To Planning Inspector

Your Ref: EN010133

Date May 2023

Having conducted a dip check of details in the Island Green Power (IGP) project documentation for Cottam Solar Project (CSP), 7000 Acres have identified an anomaly with a key land owner as part of Cottam 1, whereby:

Land Plans - Onshore
 Sheet 10 of 19

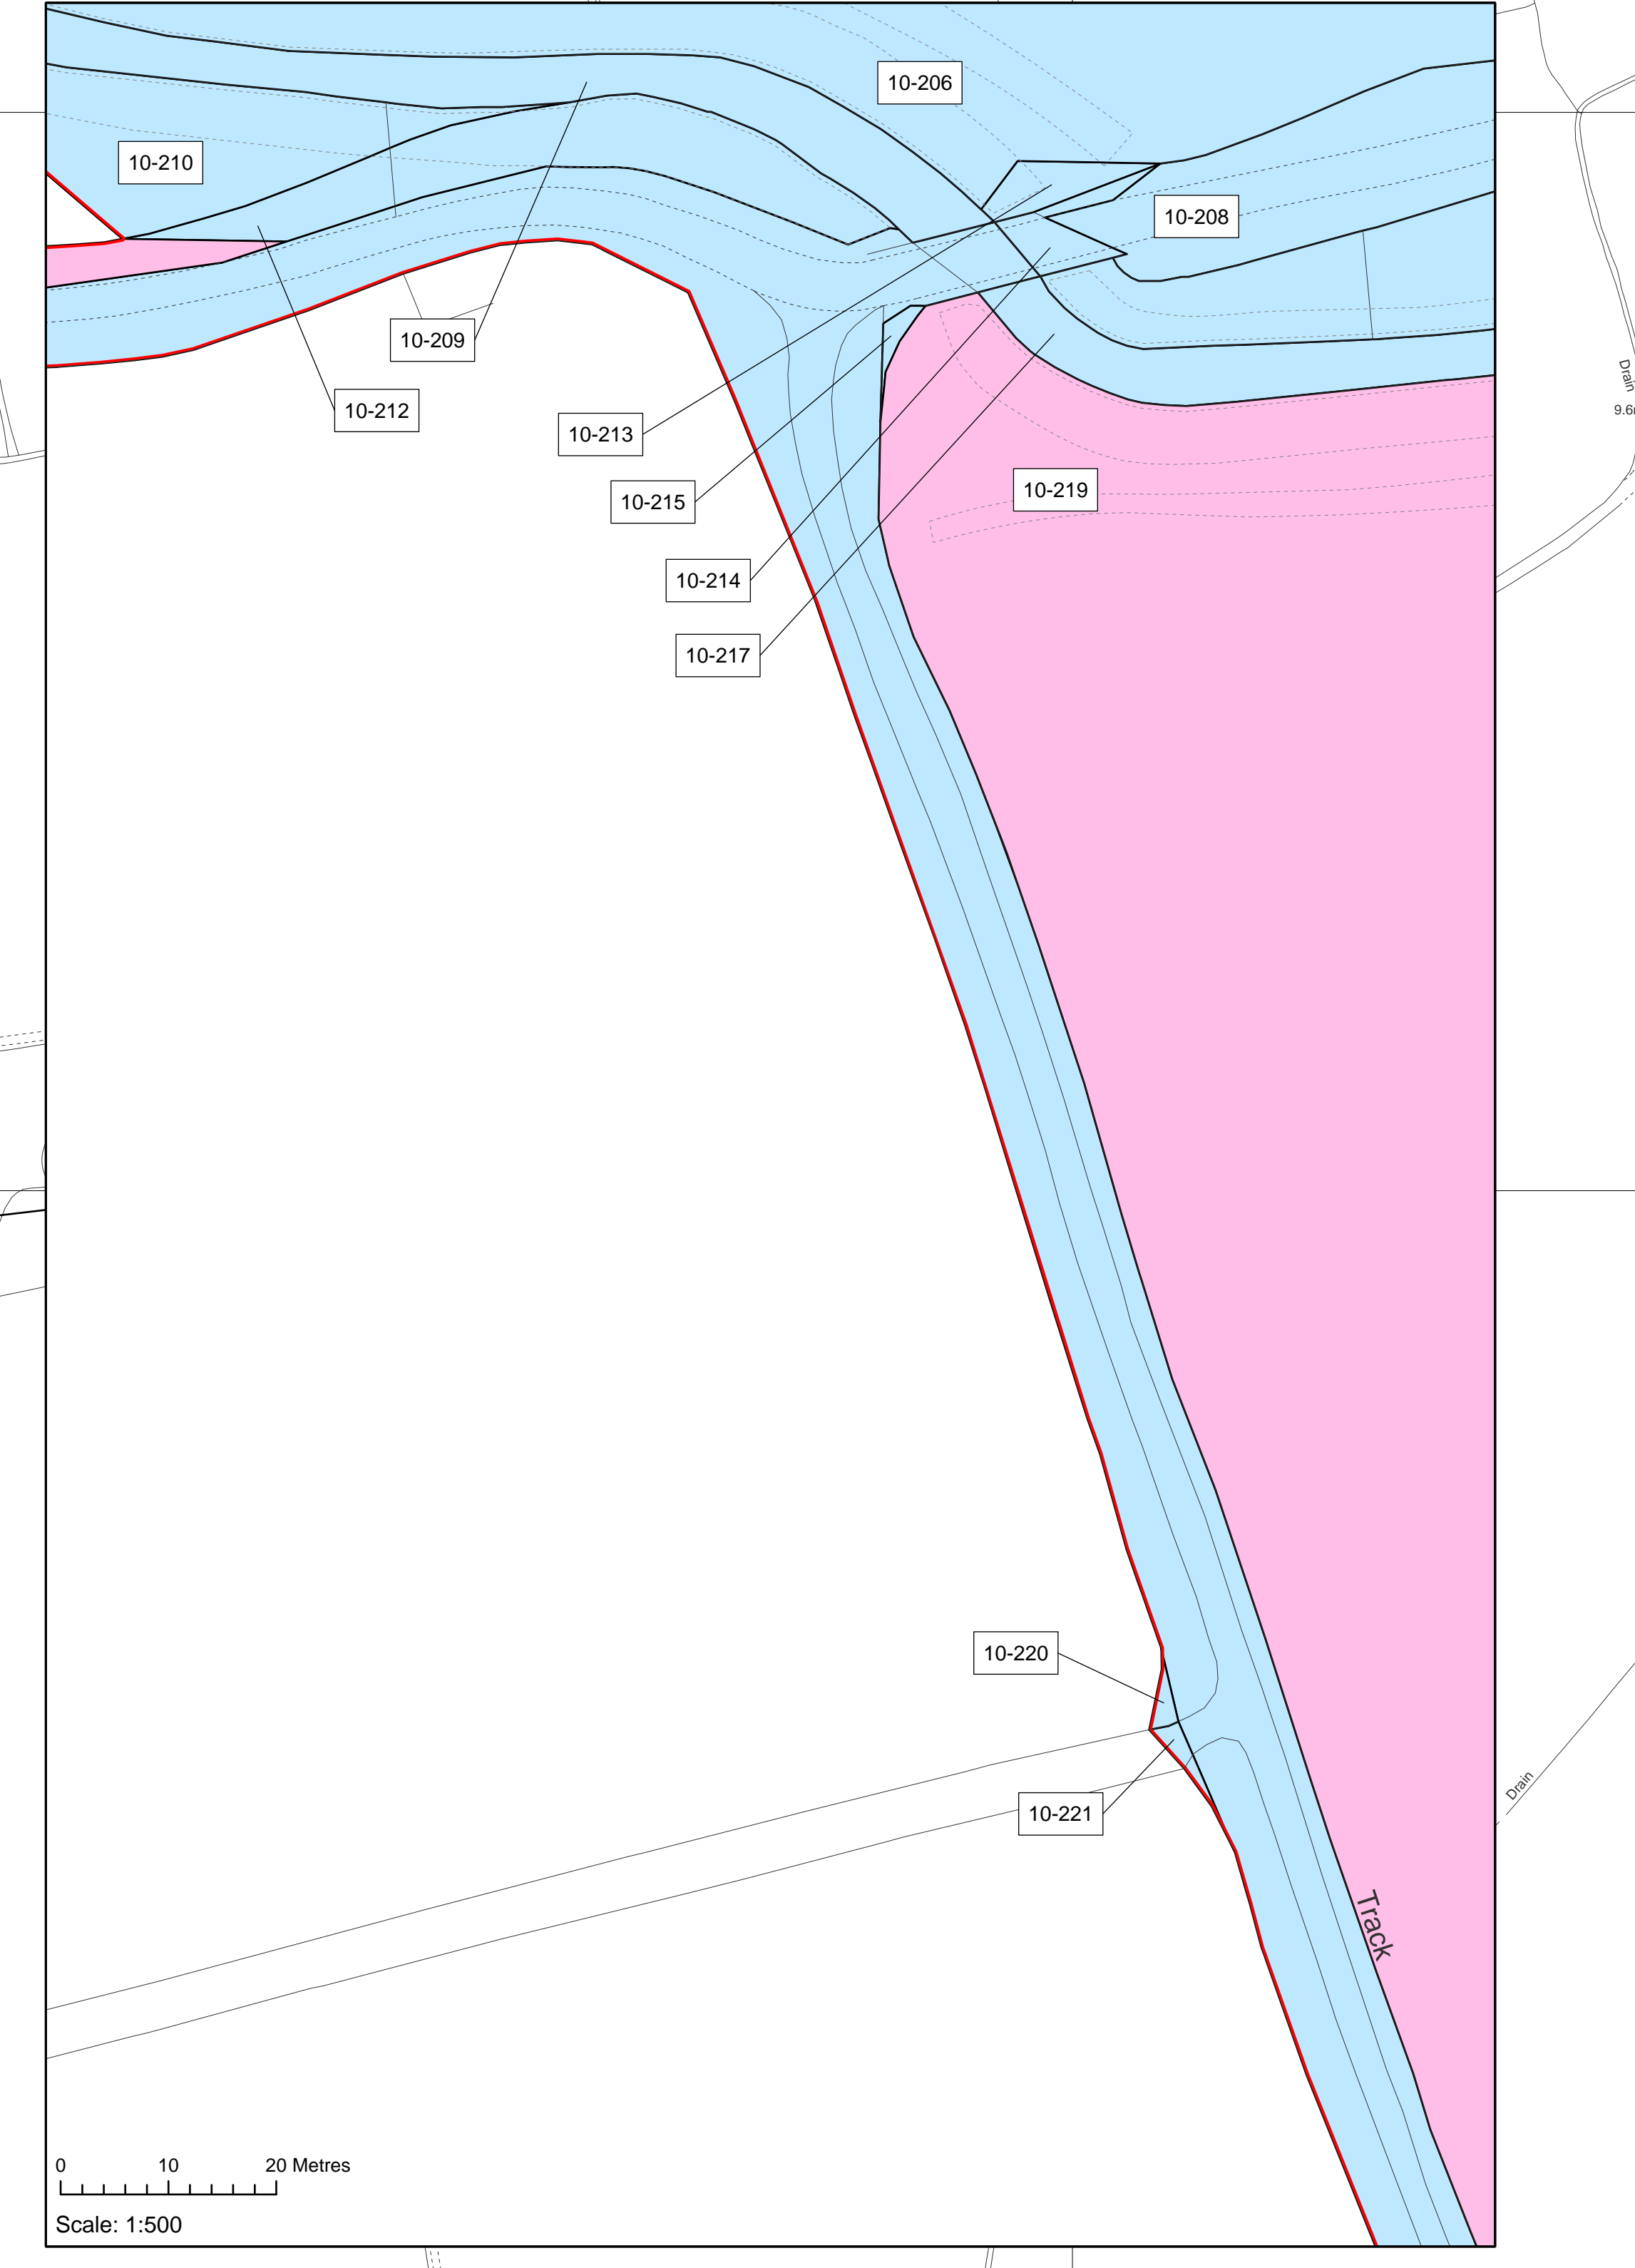
- the landowner quoted in the IGP Book of Reference does not correspond with Land Registry records:

IGP Book of Reference	Land Registry
e.g. 10 241 (Land Plan reference) Tillside Limited Templegarth, Northfield Lane, Willoughton, Gainsborough. DN21 5RT	e.g. LL322873 Kevin Simon Webster, James Charles Stewart Reynolds Milligan-Manby and John Anthony Shepherdson as trustees of the C Nicholson No1 Settlement, entry date 5 March 2019

7000Acres would ask for the IGP documentation to be verified and corrected such that there is confidence in the material provided.
